Ribble Valley Borough Council
Council Offices
Church Walk,
Clitheroe
Lancashire
BB7 2RA

Phone: 0300 123 6780
Email: developeras@lancashire.gov.uk
Your ref: 3/2026/0073
Our ref: 3/2026/0073/HDC/KW
Date: 02 March 2026

Location: Poor Parts Barn Hellifield Road Bolton-By-Bowland BB7 4LU
Proposal: Conversion of a redundant barn to an affordable local needs occupancy residential dwelling. Installation of a package treatment unit.
Grid Ref: 379667, 450117

Highway Development Control

Proposed Ground Floor Plan
Scale (1:50)

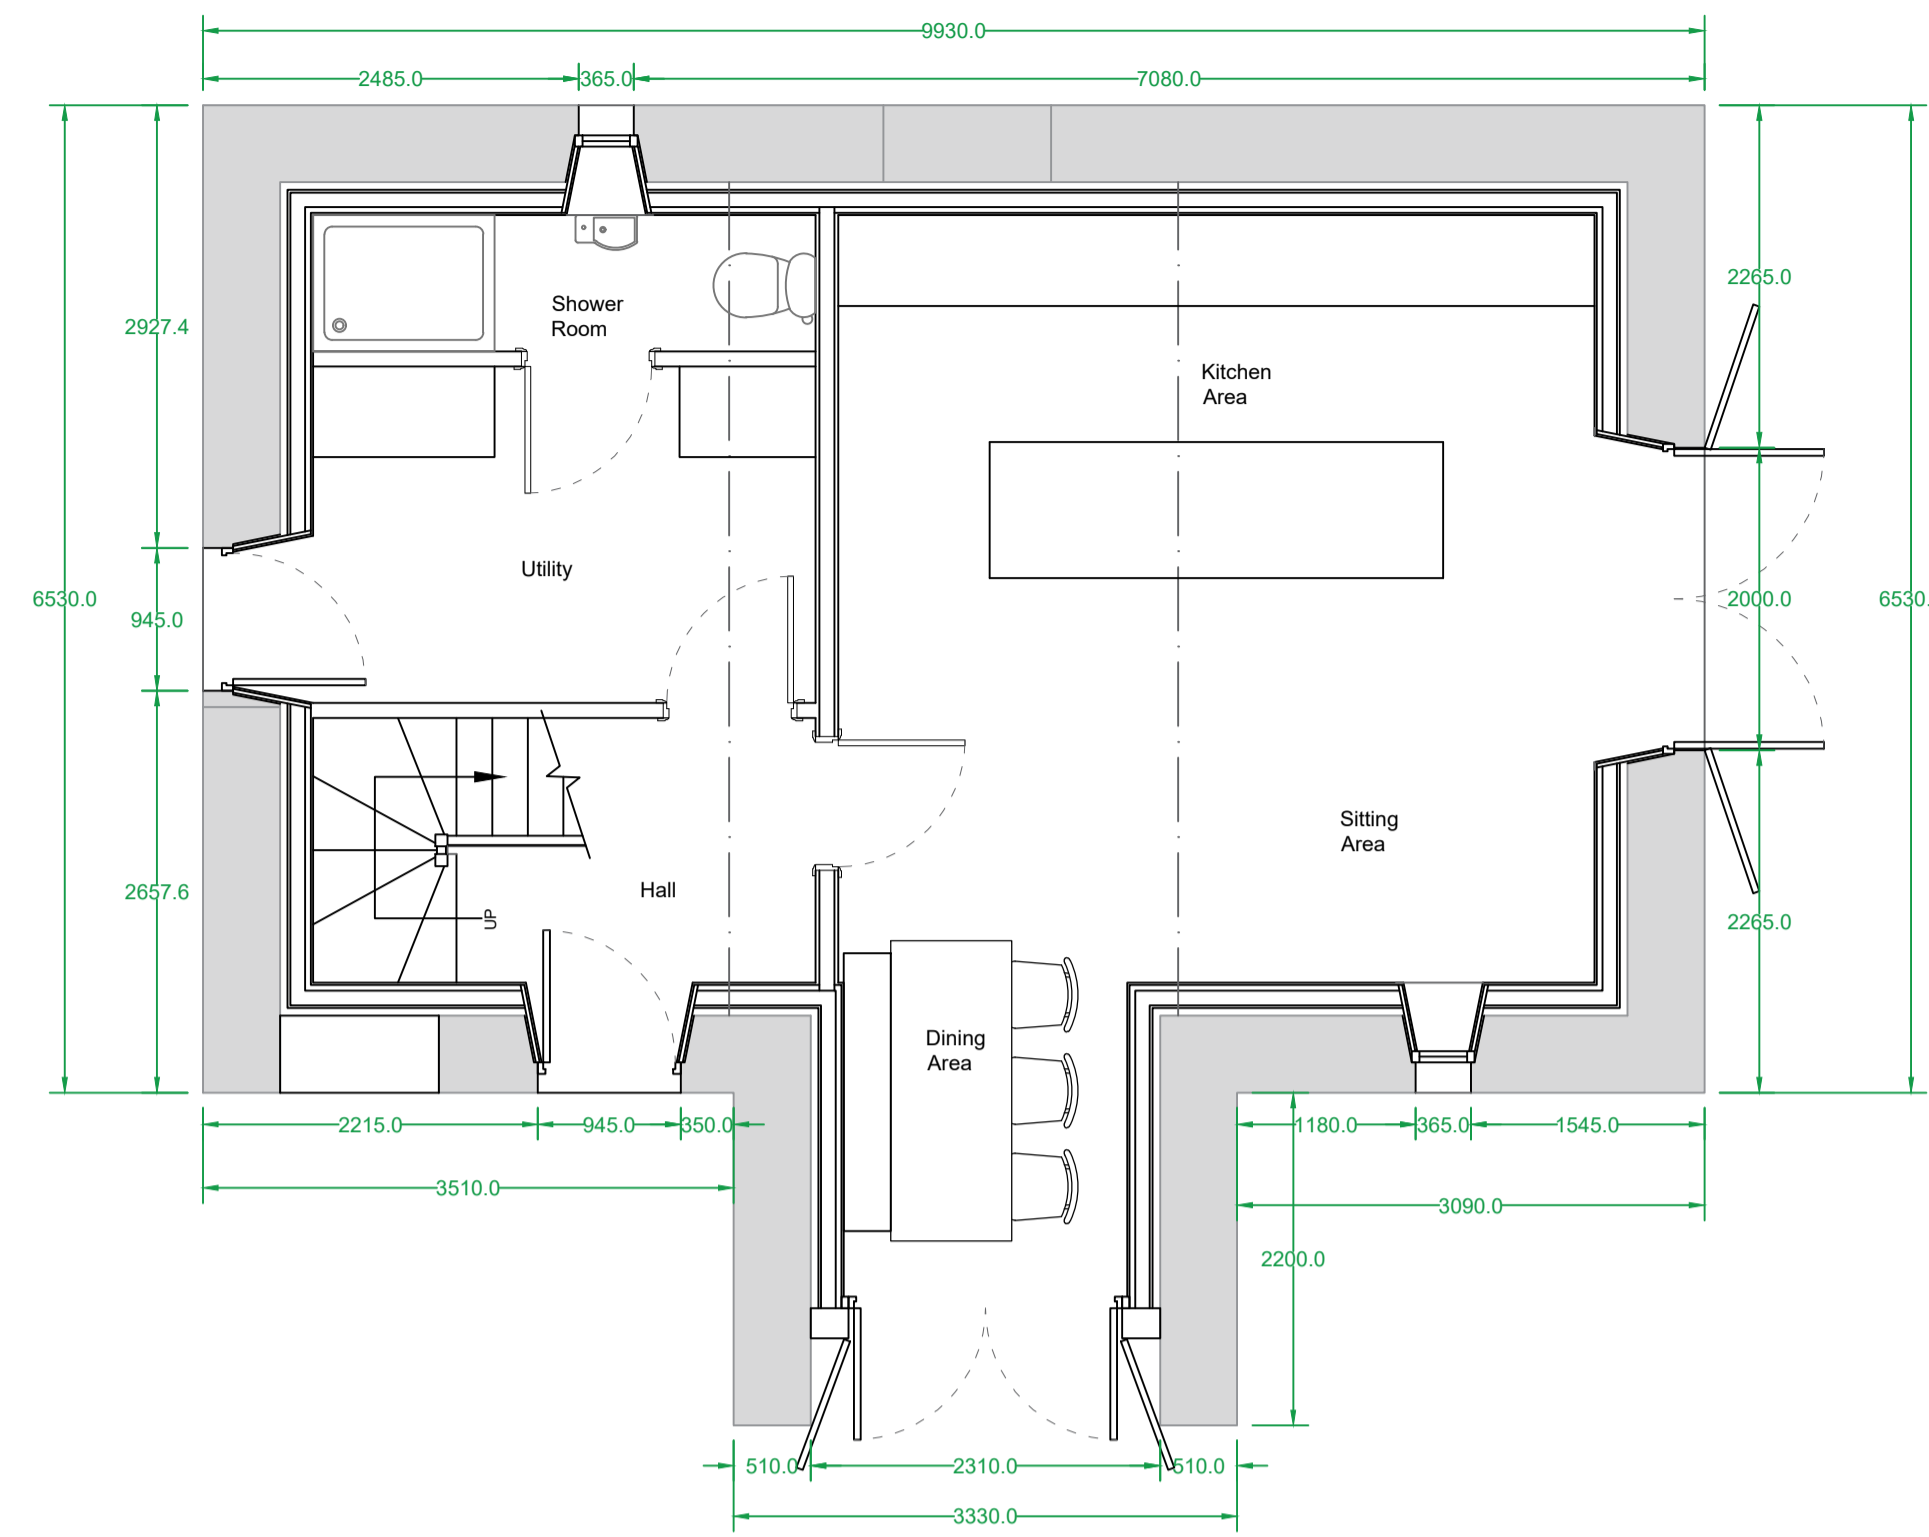
The access will require improvements following the intensification of use within the site, the access shall be hard paved for 10m into the site to ensure no debris is transported onto the network. The proposed gate is set back over 10m behind the highway edge, which is acceptable for the nature of the development. Access improvement or alteration will require the applicant to enter into a Section 171 agreement with Lancashire County Council.

The LHA understand that a visibility splay has been provided for the site access, which is 2m x approximately 28m Southbound and 32m Northbound. Given that the access leads to a classified road, the visibility splay should be set back 2.4m and the extent for 215m along the nearside edge of Hellifield Road in line with the posted speed limit.

The visibility splay should be wholly within the land which the applicant controls and/or the adopted highway, and nothing shall be erected, retained, planted and / or allowed to grow at or above a height of 0.9 metres above the nearside carriageway level which would obstruct the visibility splay of the proposed access. The red edge drawing should be supported with a blue edge to highlight if the surrounding land falls within the applicant's control, in particular where visibility splays cross outside the adopted highway.

The applicant should provide accurate details of the required sight line requirement before determining the application.

The LHA have reviewed the Proposed Site Plan and is aware that the dwelling complies with the parking standards as defined in the Joint Lancashire Structure Plan. There is also room to turn within the site, allowing for ingress and egress in forward gear.
